WAL-MART STORES, INC. STORE NO. 2924	06/08/2022
PROJECT: Albuquerque, NM	City Traffic Comments
PROJECT NO. 02924-246	PR-2021-006018

RE: Walmart at Coors (2550 Coors Blvd. NW) - Administrative Amendment Request - #PR-2021-006018

Please find responses below in bold addressing Transportation Review comments received 05/17/2022

SITE PLAN

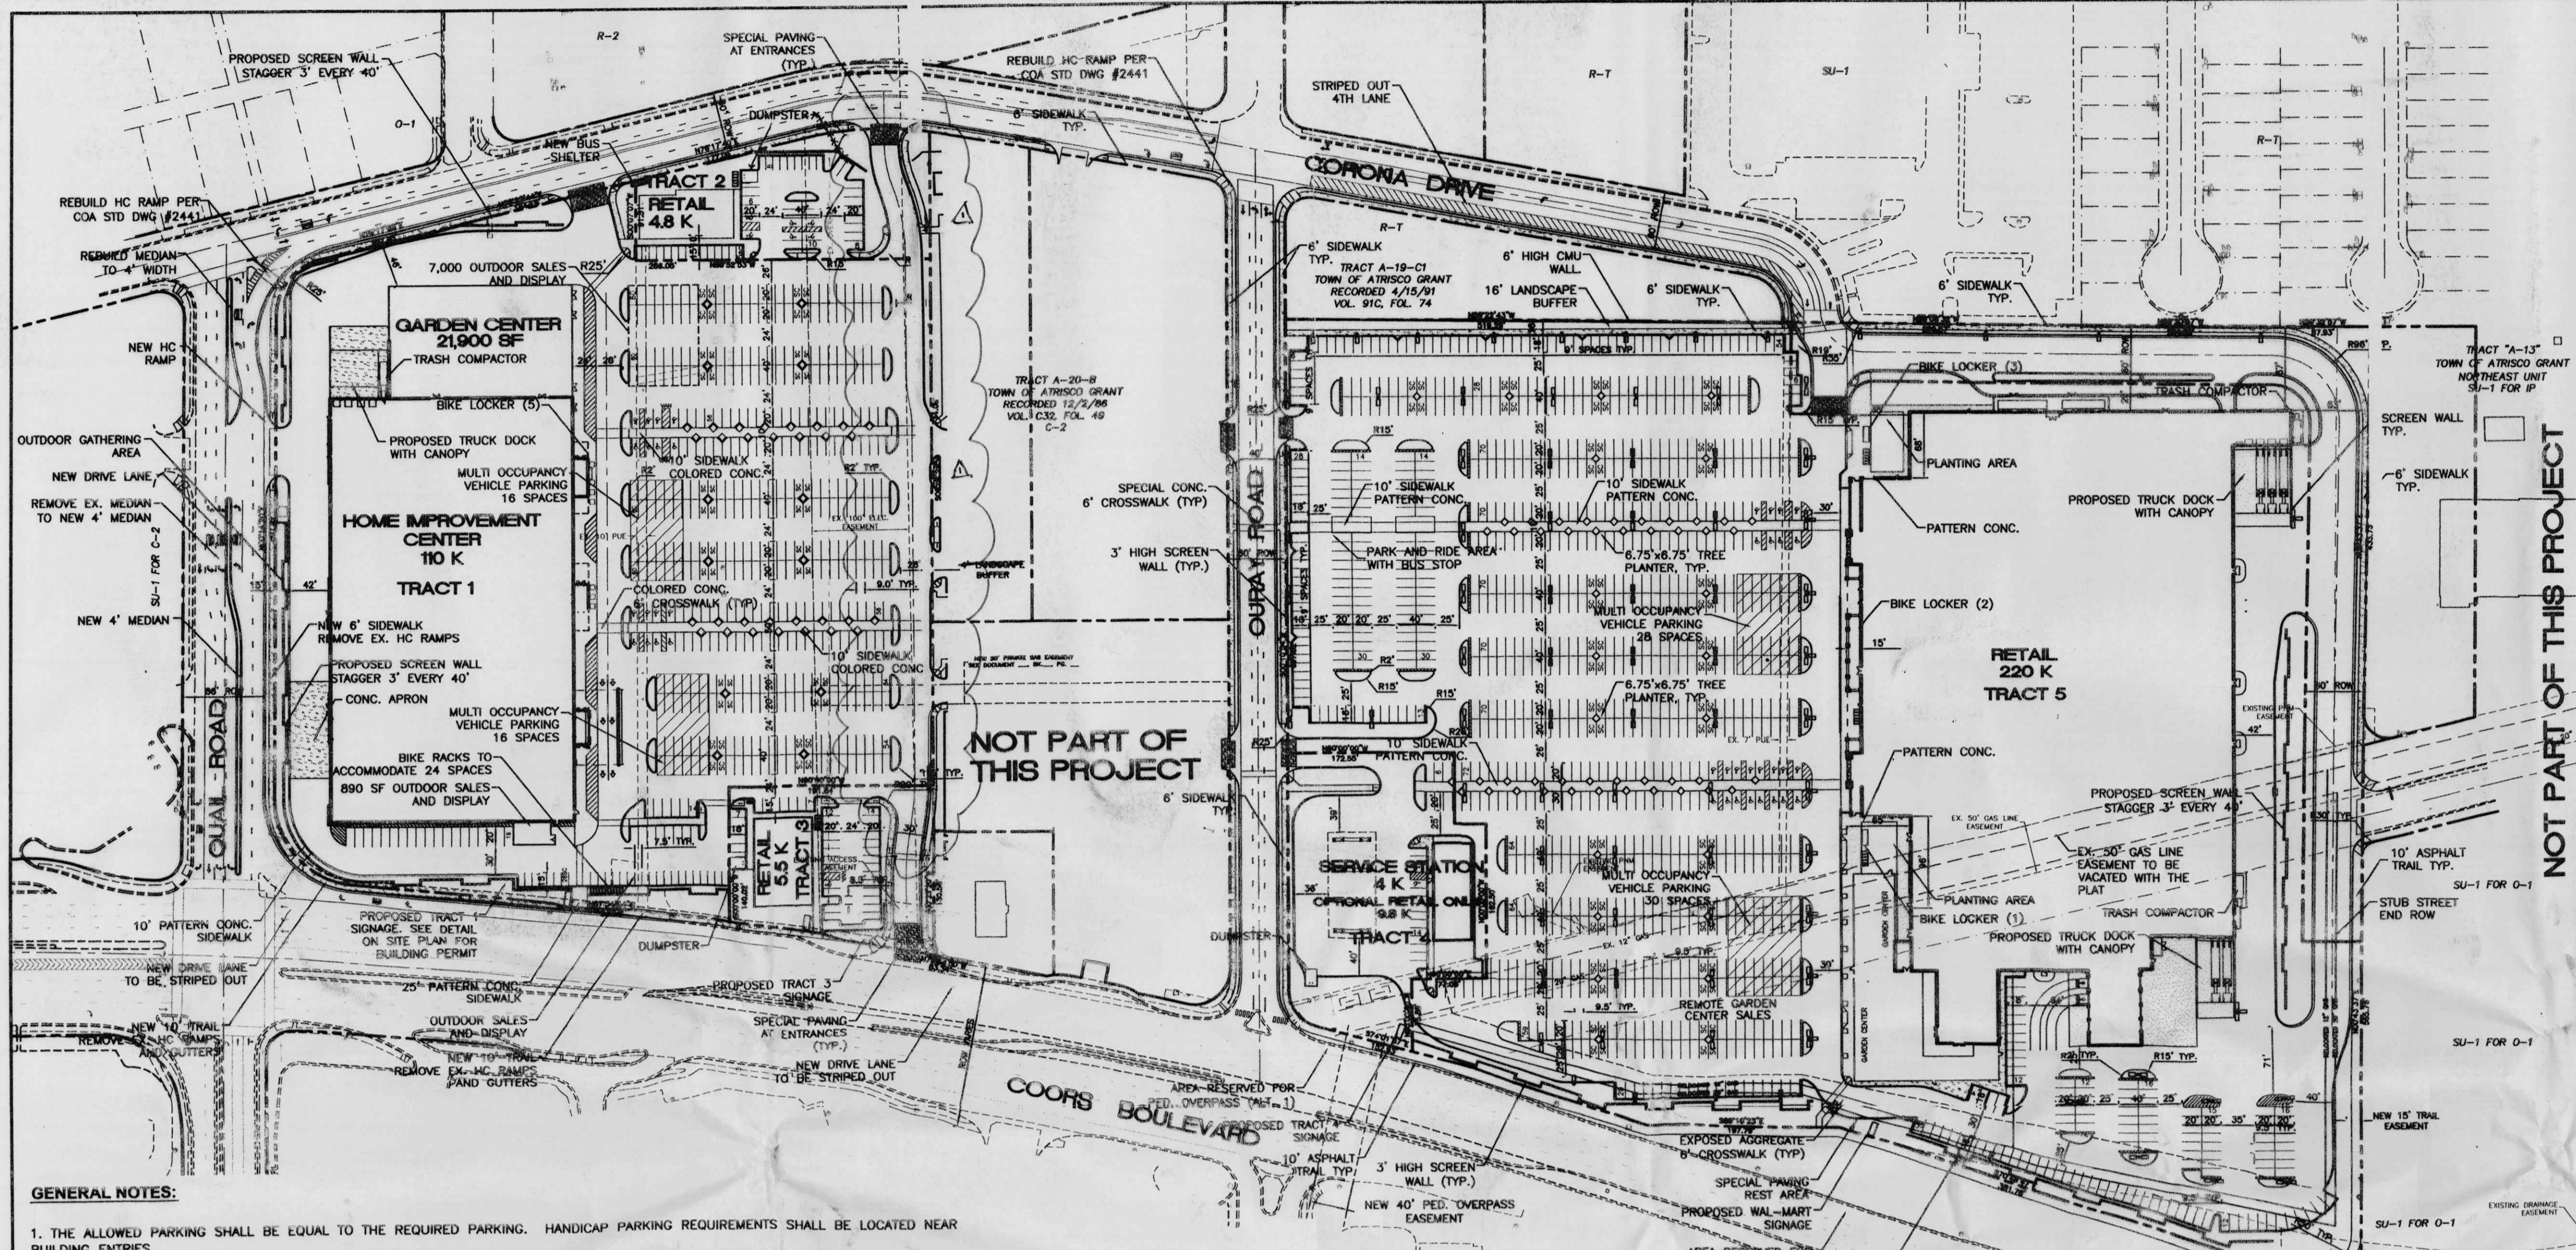
3. Place curb ramps along the pedestrian route as needed. When showing curb ramp removal, there needs to be curb ramps on both sides of the drive aisle.

Response: The parking island adjacent to the proposed MFC expansion area has been revised to more clearly indicate that the pavement in the area is flush and does not warrant further curb ramps. The pedestrian crosswalk terminates on the east side of the MFC at flush concrete pavement along the building frontage road. See revised sheet 6002 – C1.1 Site Plan for more information.
